CITY OF ALBUQUERQUE

June 8, 2021

Re: Central Apartments
1020 Central Ave SW
Traffic Circulation Layout
Architect's Stamp 01-21-2021 (K13-D080; BP-2020-43281)

SHEET TITLE:  
**ARCHITECTURAL SITE PLAN &  
TRAFFIC CIRCULATION LAYOUT**

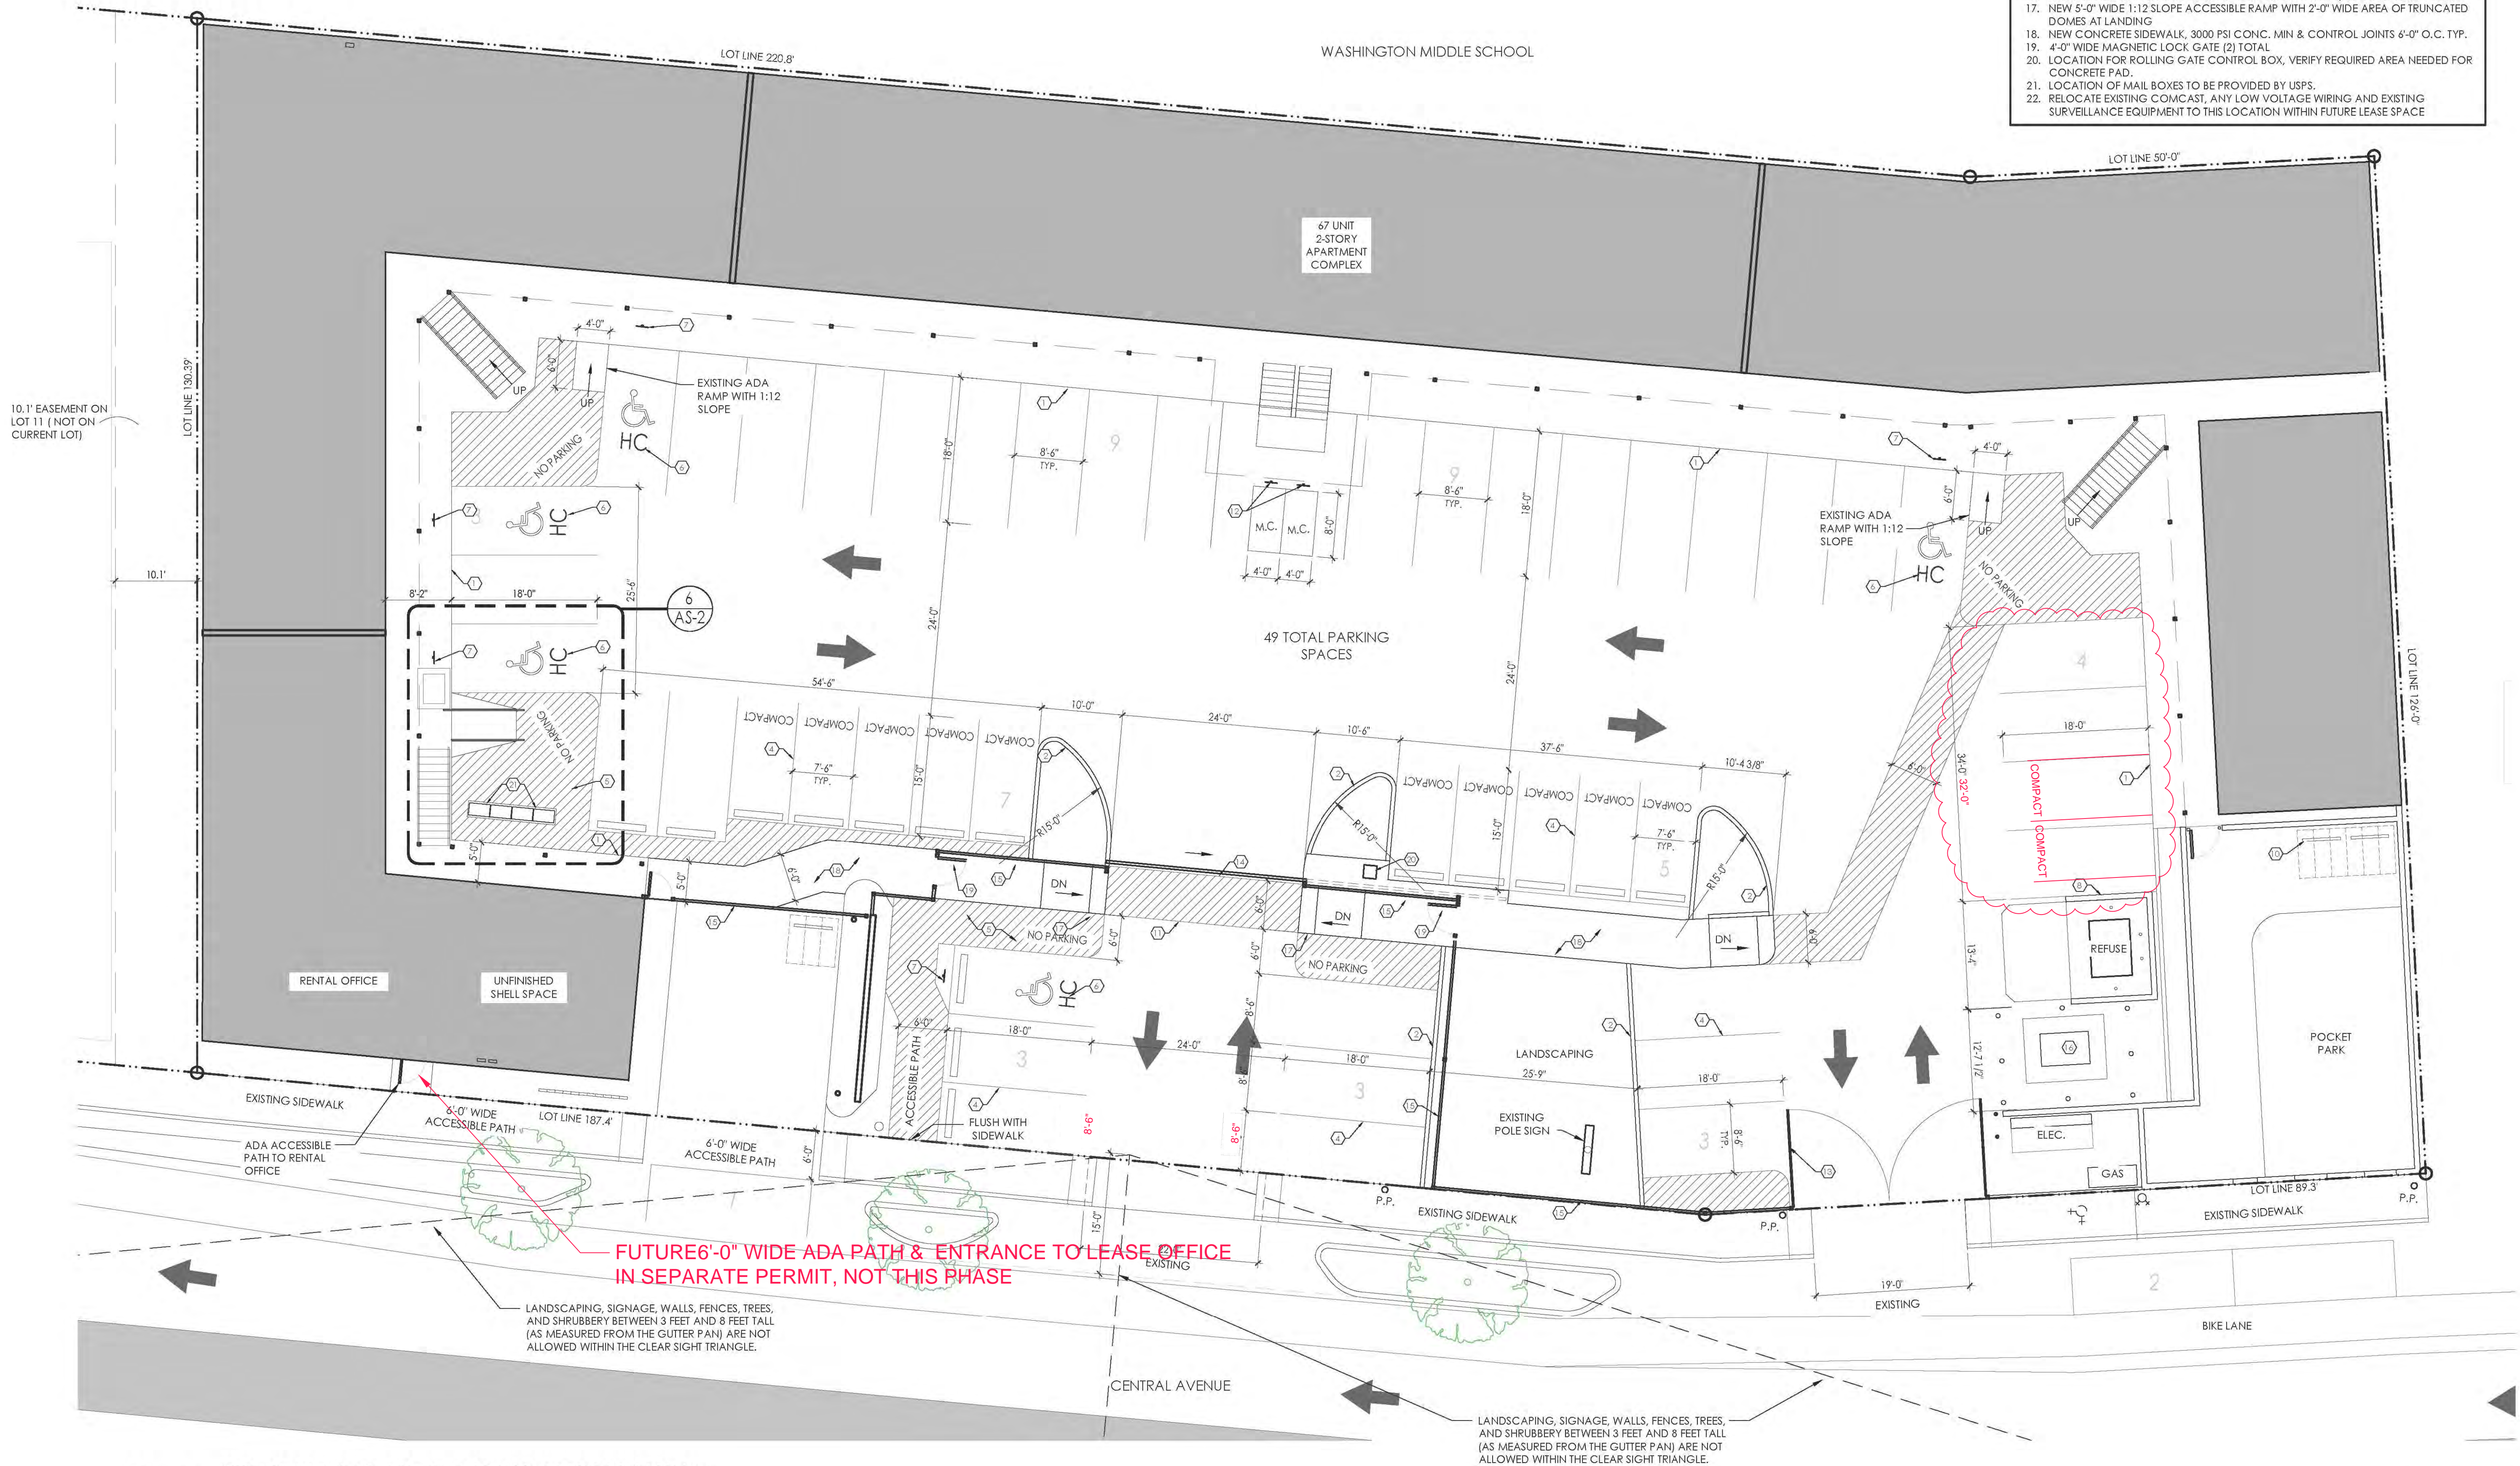
- "Emergency Access Only" signs for the west entrance. (These were mentioned in the response letter to the TCL comments but were not shown on the actual plan submittal.)
- Sufficient dimensioning shall be provided behind the planter for wheelchair access at the northeast corner of the parking lot. (An overall sidewalk dimension was shown, but there was no dimension around obstacles.)
- Due to various lot lines crossing the parking lot, a shared parking and access easement is required.
